MECKLENBURG COUNTY
Park and Recreation Department

MEMORANDUM

RE: Rezoning Petition # 2008-051 Bank of America- Steele Creek Store (overland connector)

C-3.0

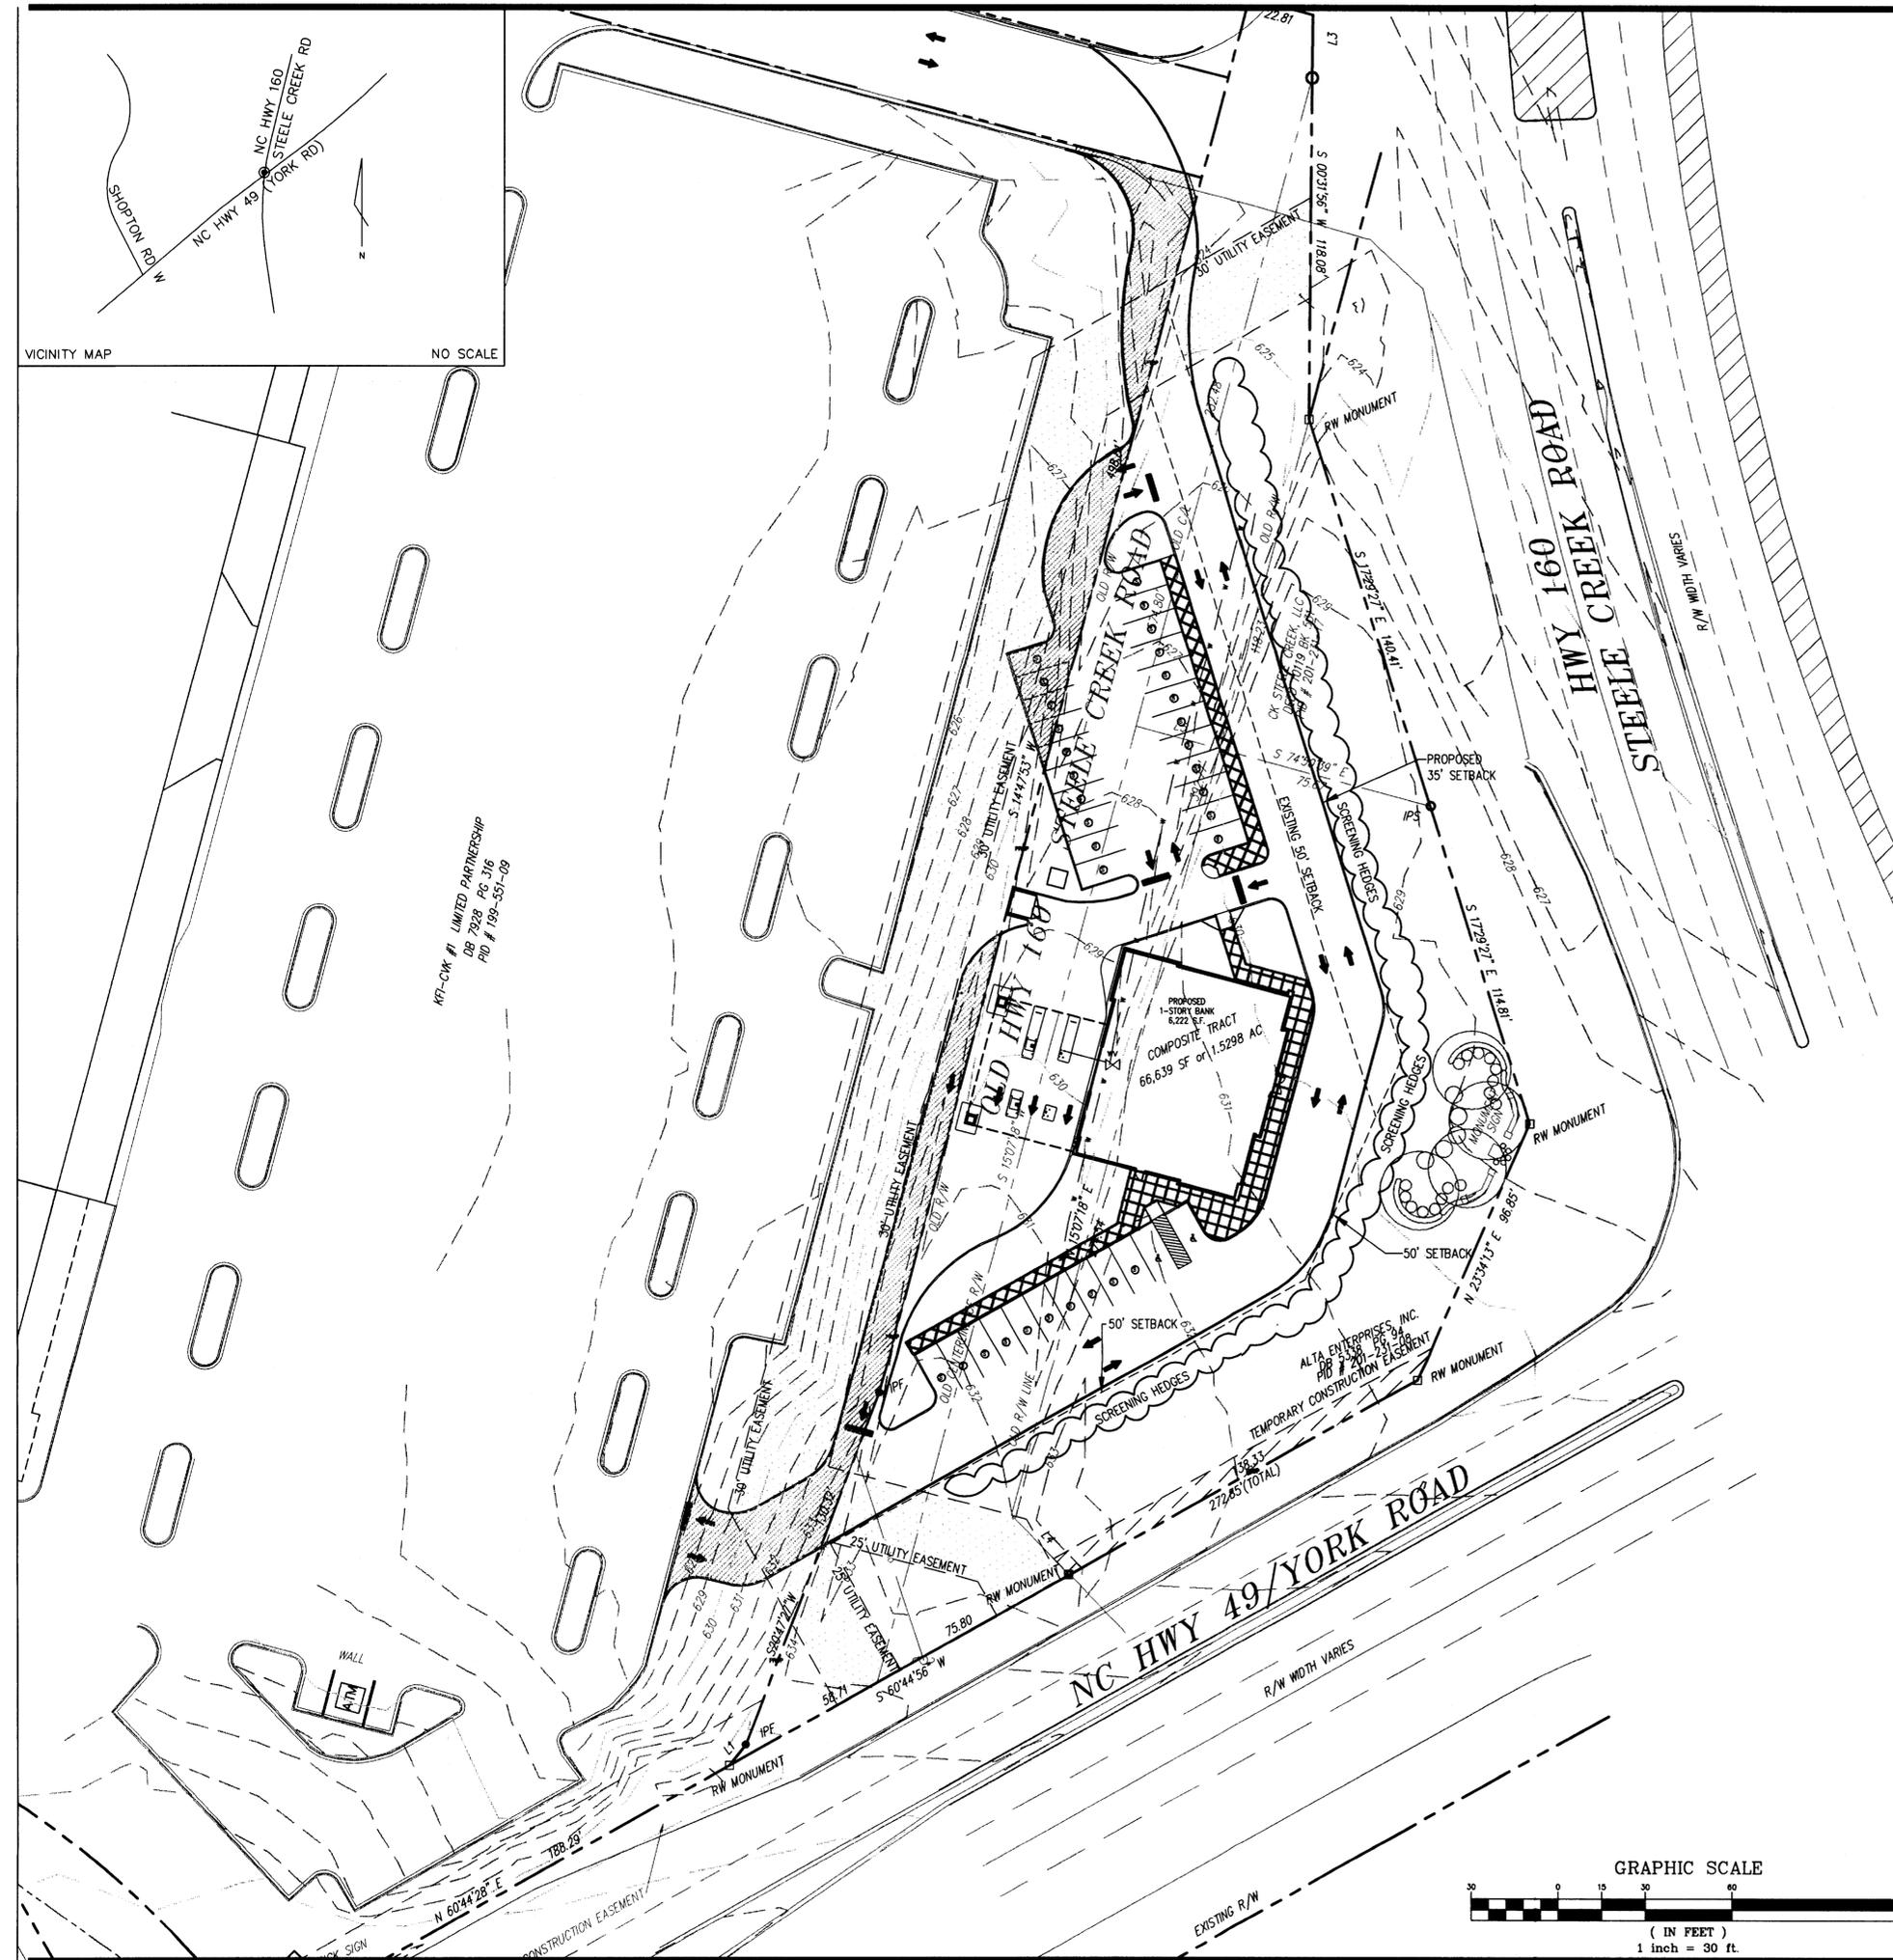
- MCPR requests that the petitioner provide a minimum 8' wide planting strip and 8' wide

sidewalk along South Tryon Street.
